Our ref: HMS Application No 1444

Notice of Exhibition of application for MOD 2, Proposed design modifications (SSD-10384 - Mod-2)

It is noted that this modification application follows a State Significant Development Approval that was issued for the alterations and additions to the Sirius building including 'restoration and refurbishment for a mixed-use development' on 18 June 2021.

2 40G - DETAIL - SECTION - WINDOW SILL - BALCONY TO EXISTING
1:5

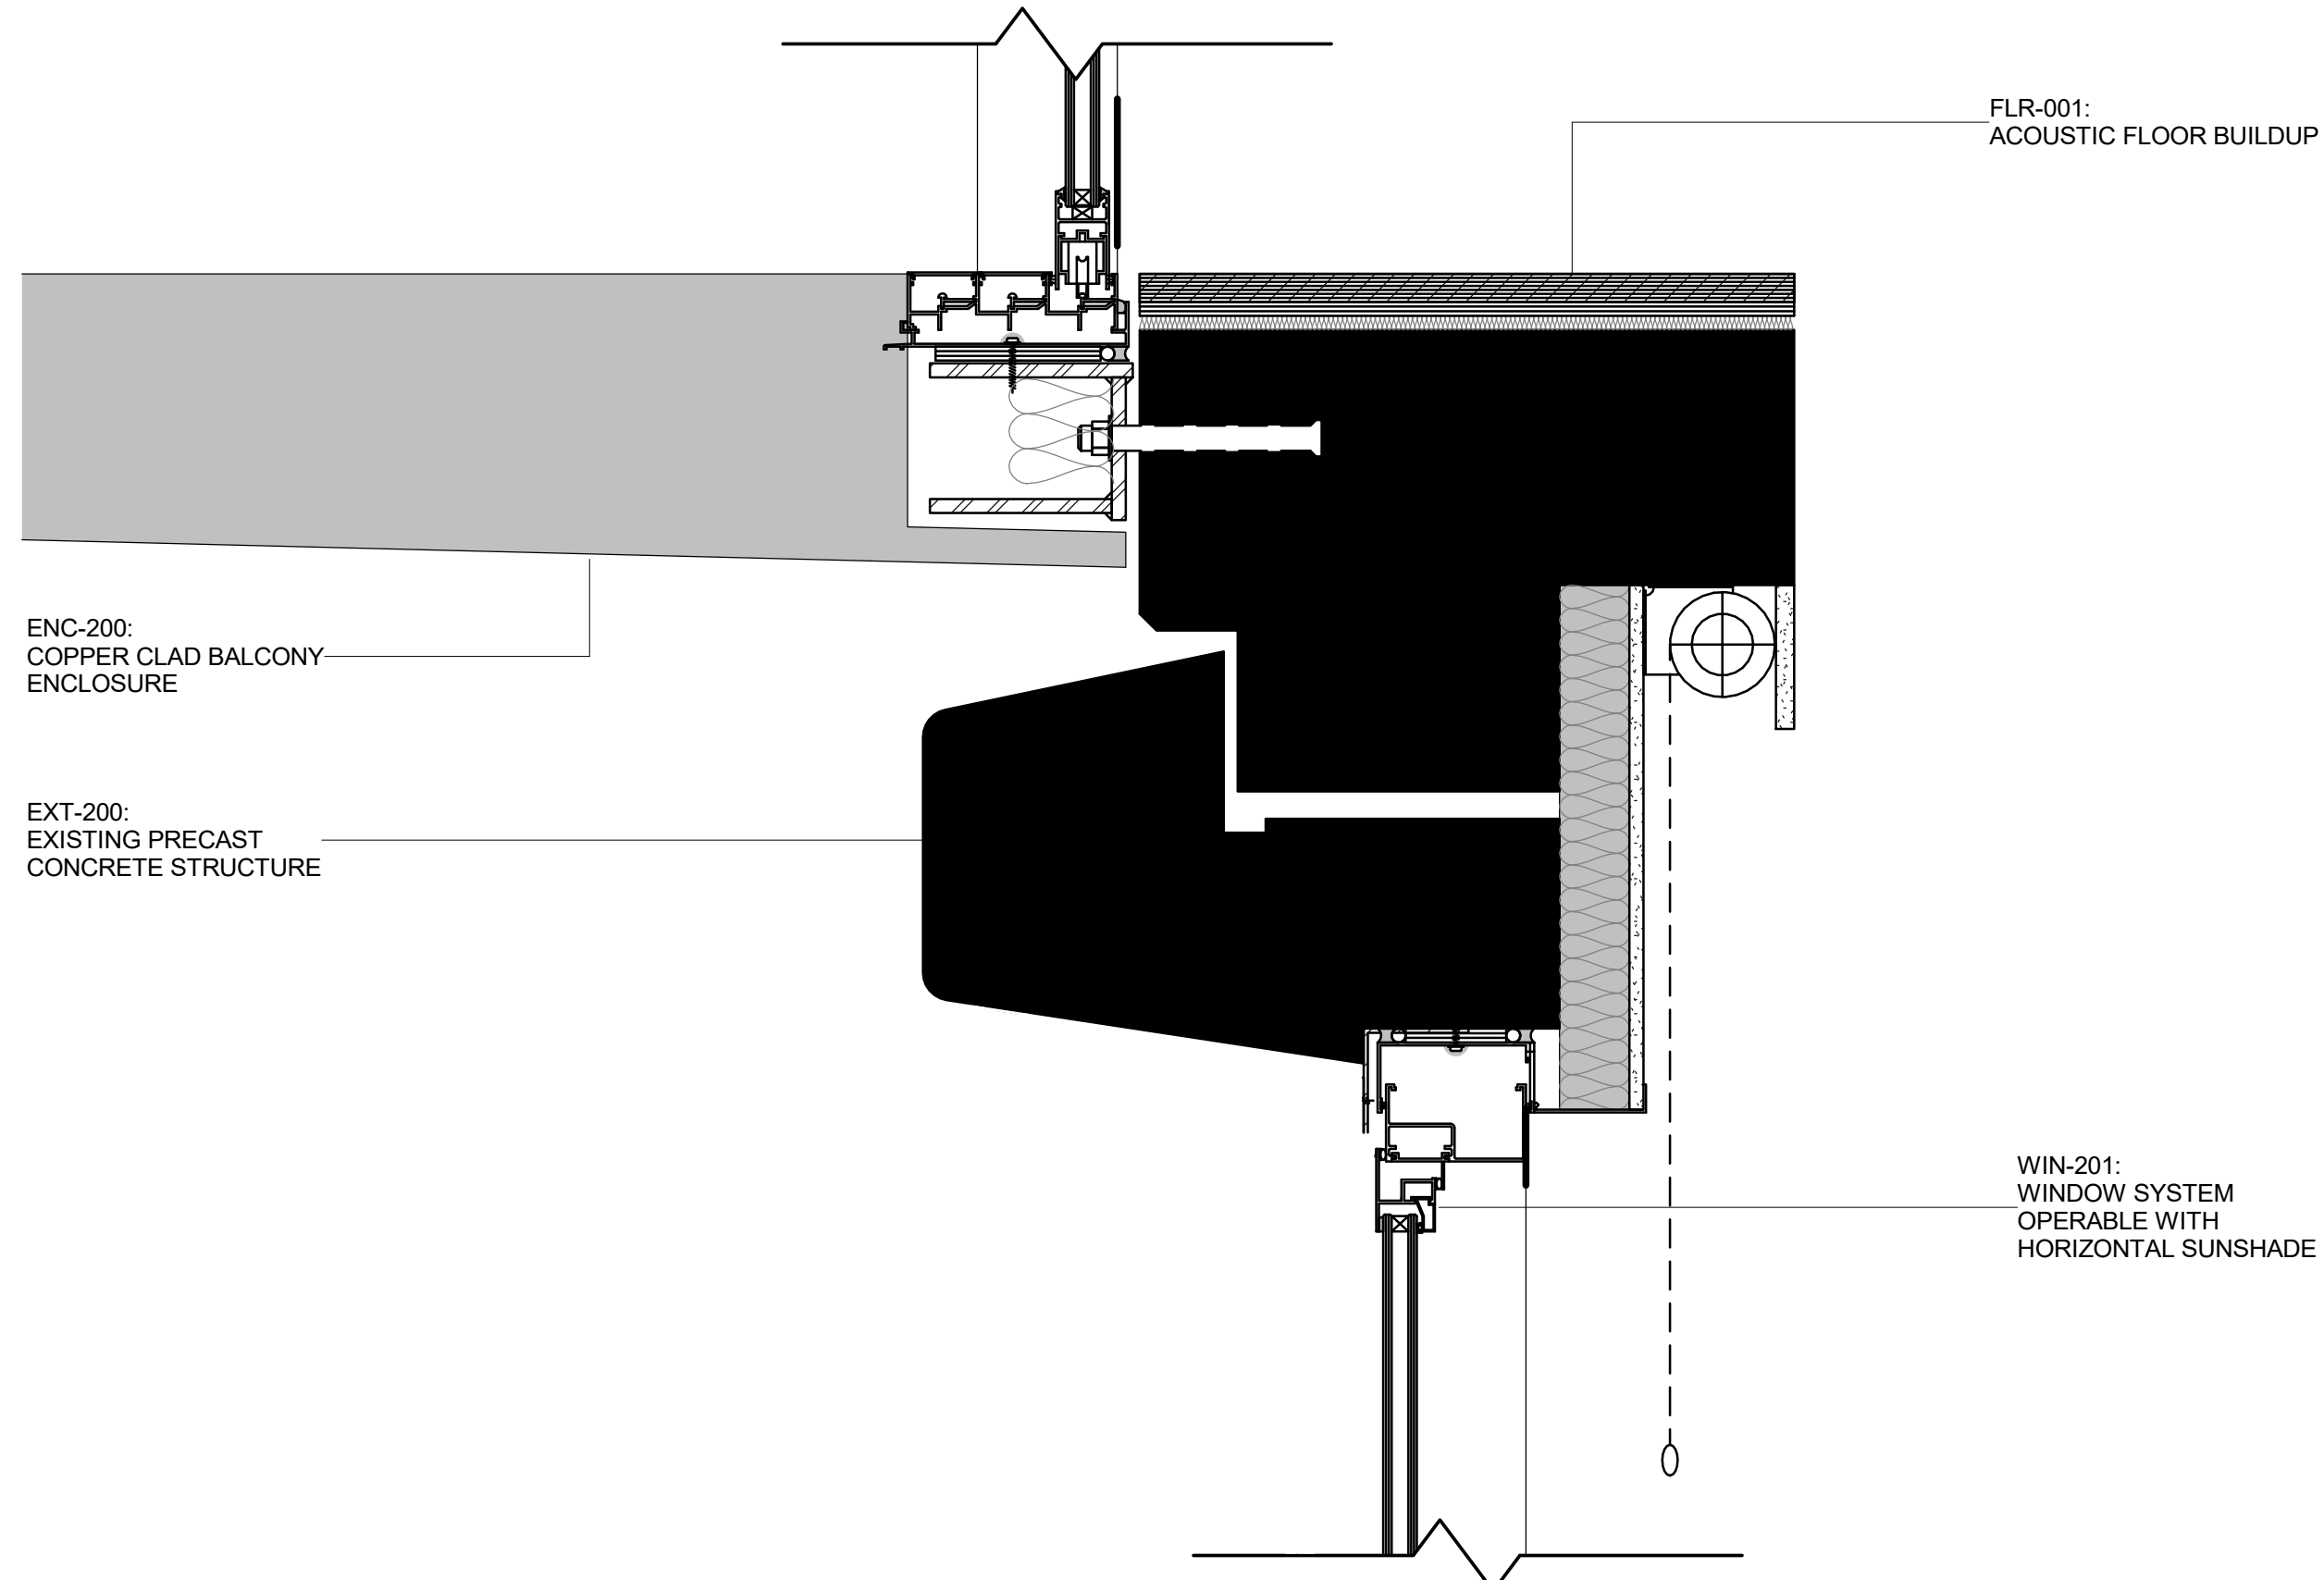
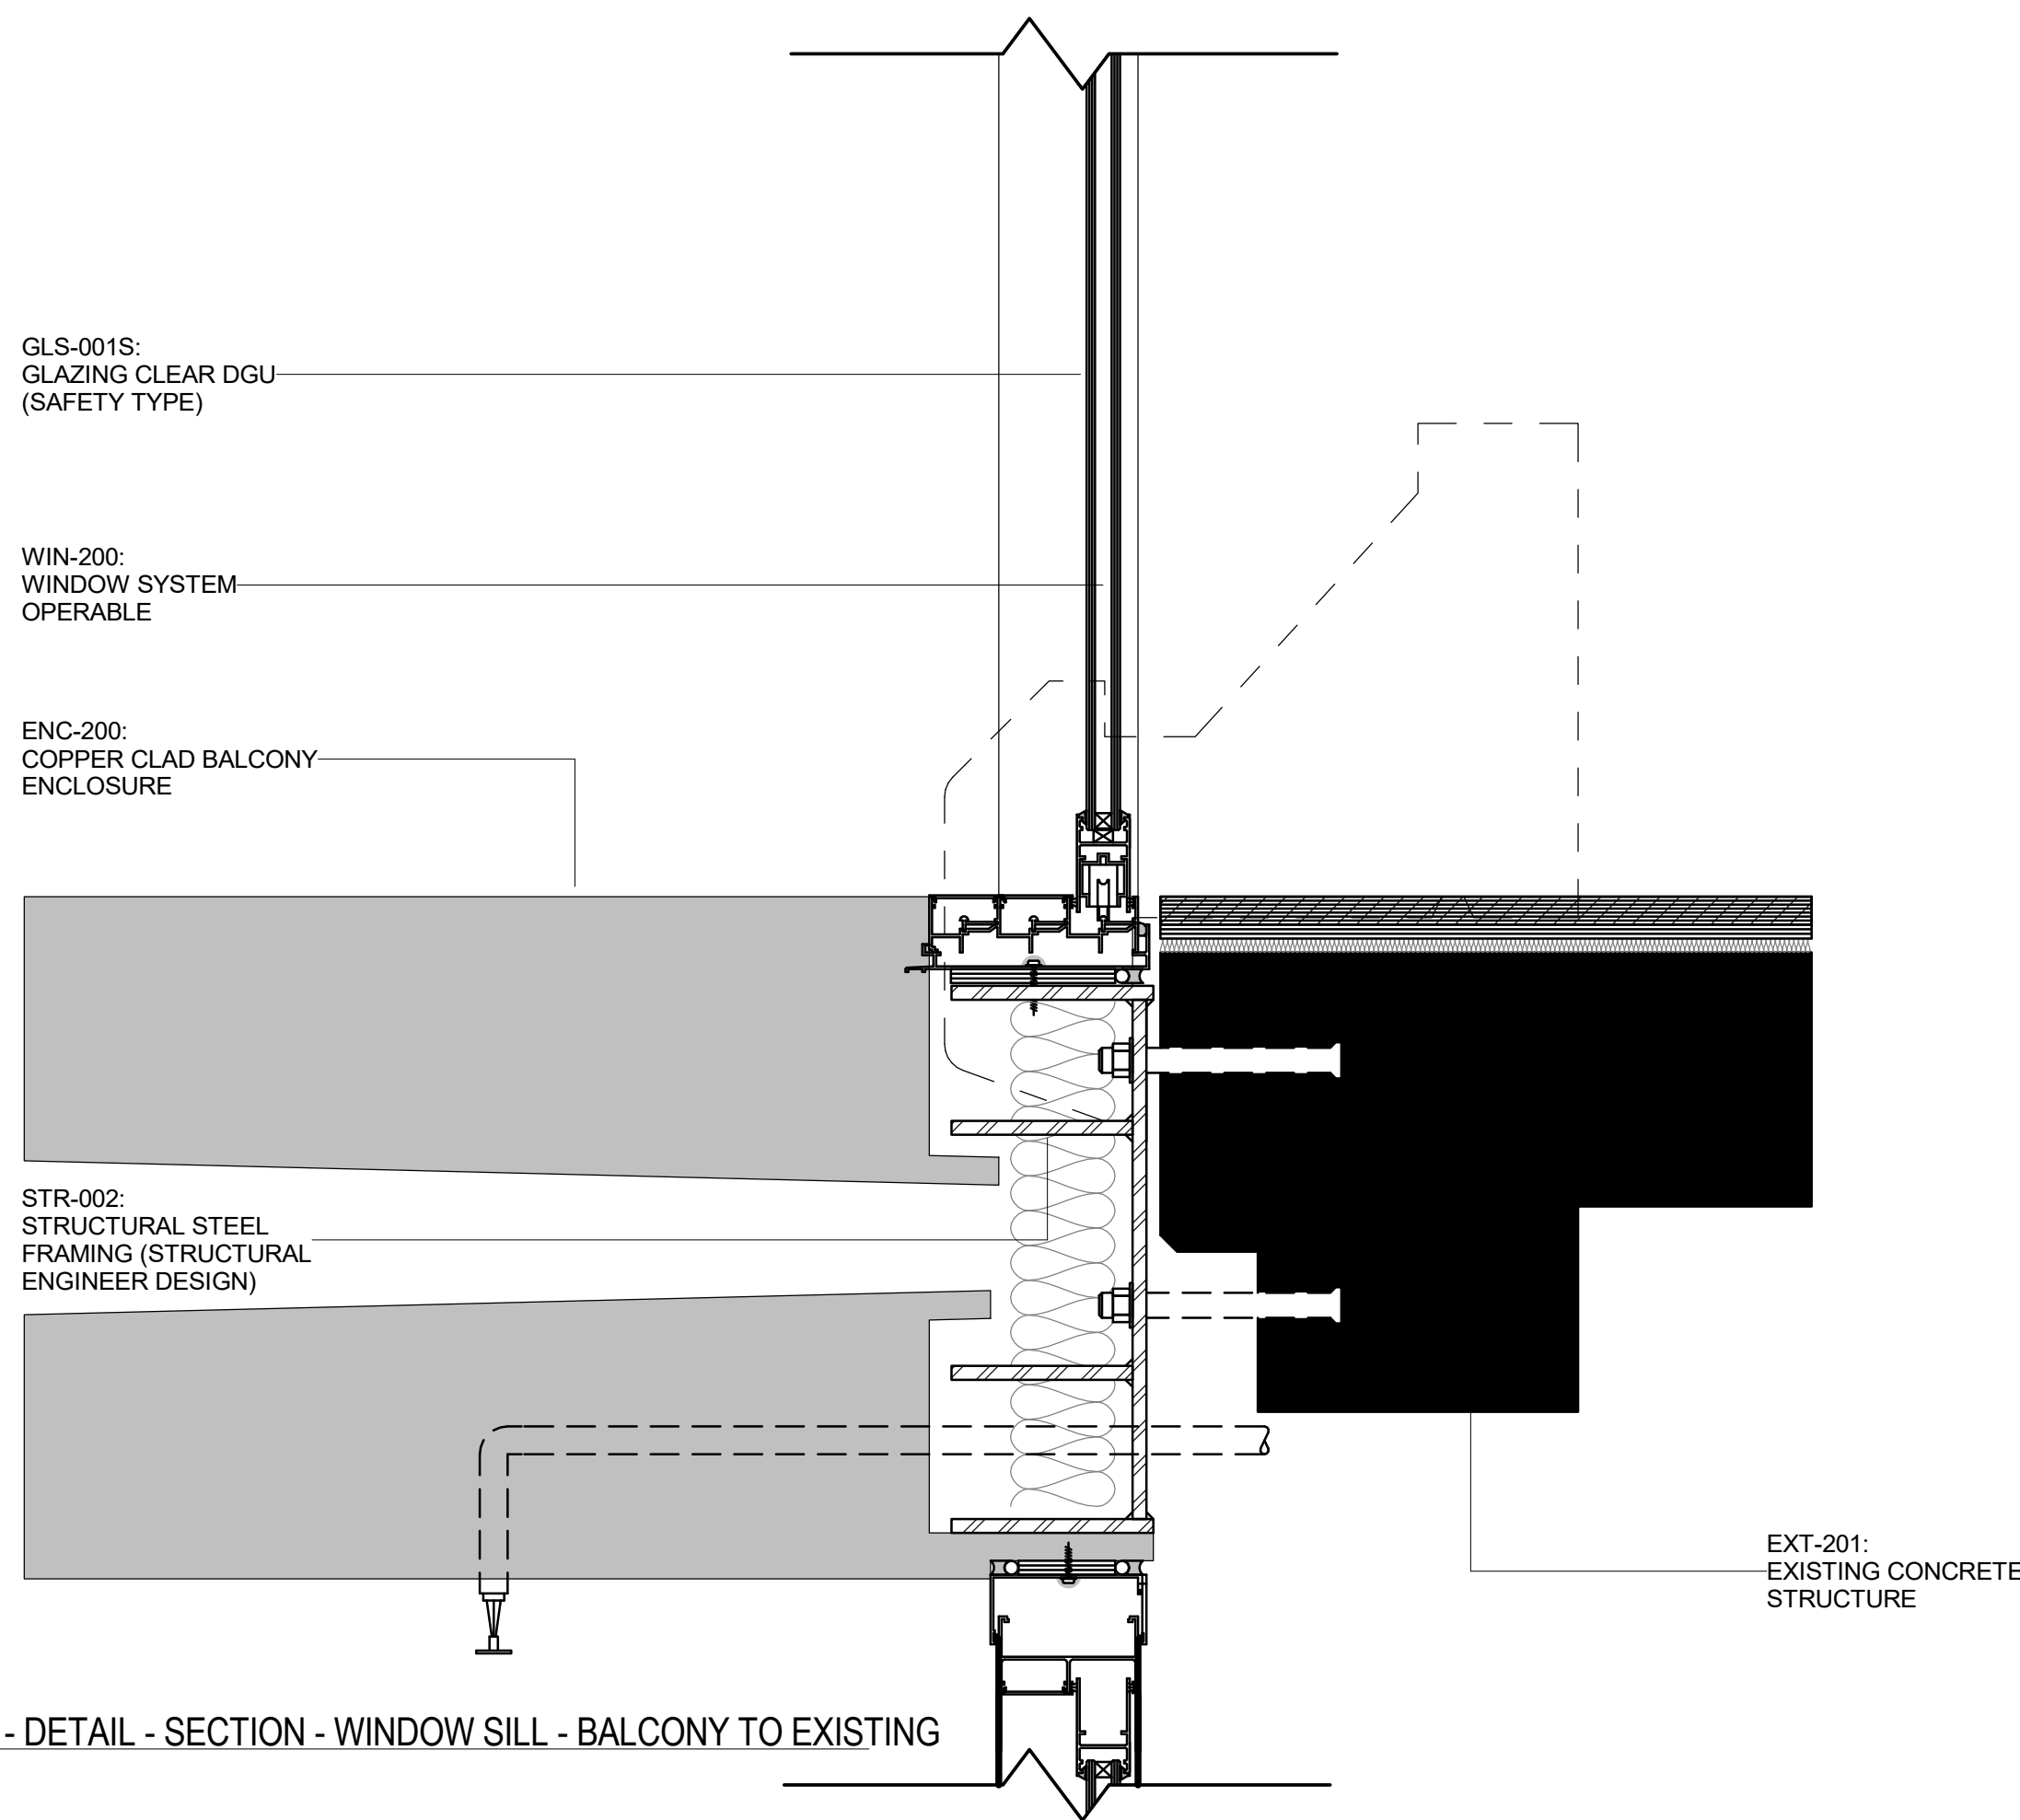
Modification to approved balconies would have some impact on the character and presentation of the building. It is, however, noted the changes are needed to comply with current NCC requirements for hydraulic drainage and climbability/safety.

Following consultation with Heritage NSW, the applicant has agreed to retain and reuse existing metal balustrades to the six terraces as noted in the attached drawing (Attachment A). On balance, the changes to the approved balconies on upper levels to replace metal balustrade with glazed balustrade (as highlighted in yellow in Attachment A) is considered acceptable.

It is further noted the treatment of balconies (highlighted in blue) at the lower levels vary from those highlighted in yellow and feature punched windows without any balustrades. The rationale for the inconsistent treatment is not clearly explained in the submitted documentation. It is considered that a more consistent treatment across all affected balconies (as highlighted in blue and yellow) would have a better outcome. This would also align better with the intent of the approved SSD that features consistent treatment to balconies with balustrades on all these levels.
